15 September 2015

CR2015/003978  
SF2012/000805  
KM

NELSON BAY ROAD (B63): EXHIBITION OF ENVIRONMENTAL ASSESSMENT - SECTION 75W MODIFICATION OF ACCESS TO MACCAS SAND PROJECT, LOT 218 DP1044608 (08\_0142 MOD 2)

SITE LAYOUT

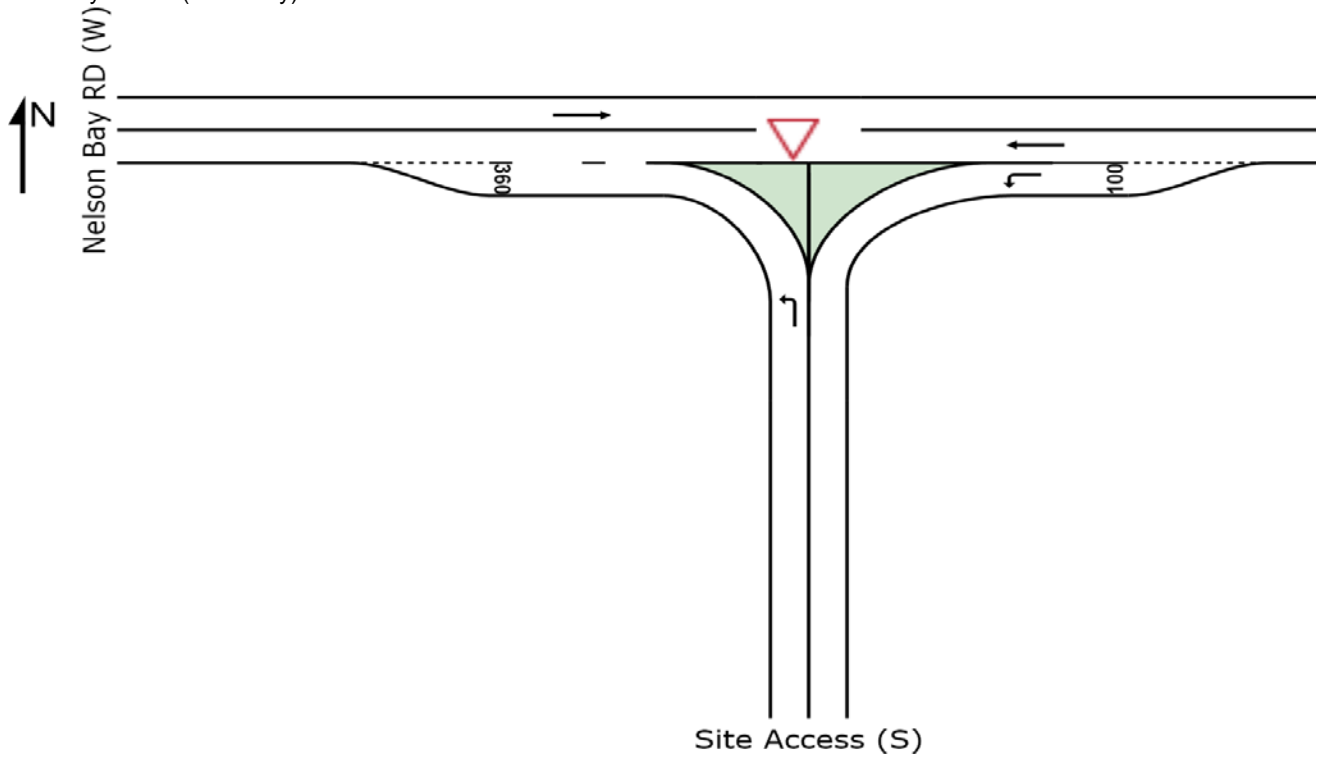
*Comment: Roads and Maritime do not consider that the SIDRA modelling as submitted in support of the TIA by the proponent was configured appropriately, and therefore additional SIDRA and microsimulation traffic modelling was undertaken by Roads and Maritime. Roads and Maritime also undertook several site visits to ensure that any traffic modelling undertaken accurately reflected the current operating conditions of the intersection.*

*The SIDRA model, when configured appropriately and in accordance with Roads and Maritime requirements, demonstrated that the proposed additional truck movements could not be accommodated during the AM peak periods, with the merge movement from the development onto Nelson Bay Road showing a LOS F. Outside the peak period however, the modelling demonstrated that there is sufficient capacity on Nelson Bay Road to accommodate proposed additional movements, with a LOS C.*

Monday to Friday	Transportation Period	RMS Proposed Truck Movements
	5am to 6am	28 (14 in / 14 out)
	6am to 9am	16 (8 in / 8 out)
	9am to 10pm	48 (24 in / 24 out)

Transportation Period	RMS Proposed Approval
5am to 6am	No change requested
6am to 7am	18 (9 in /9 out)
7am to 4pm	48 (24 in / 24 out)
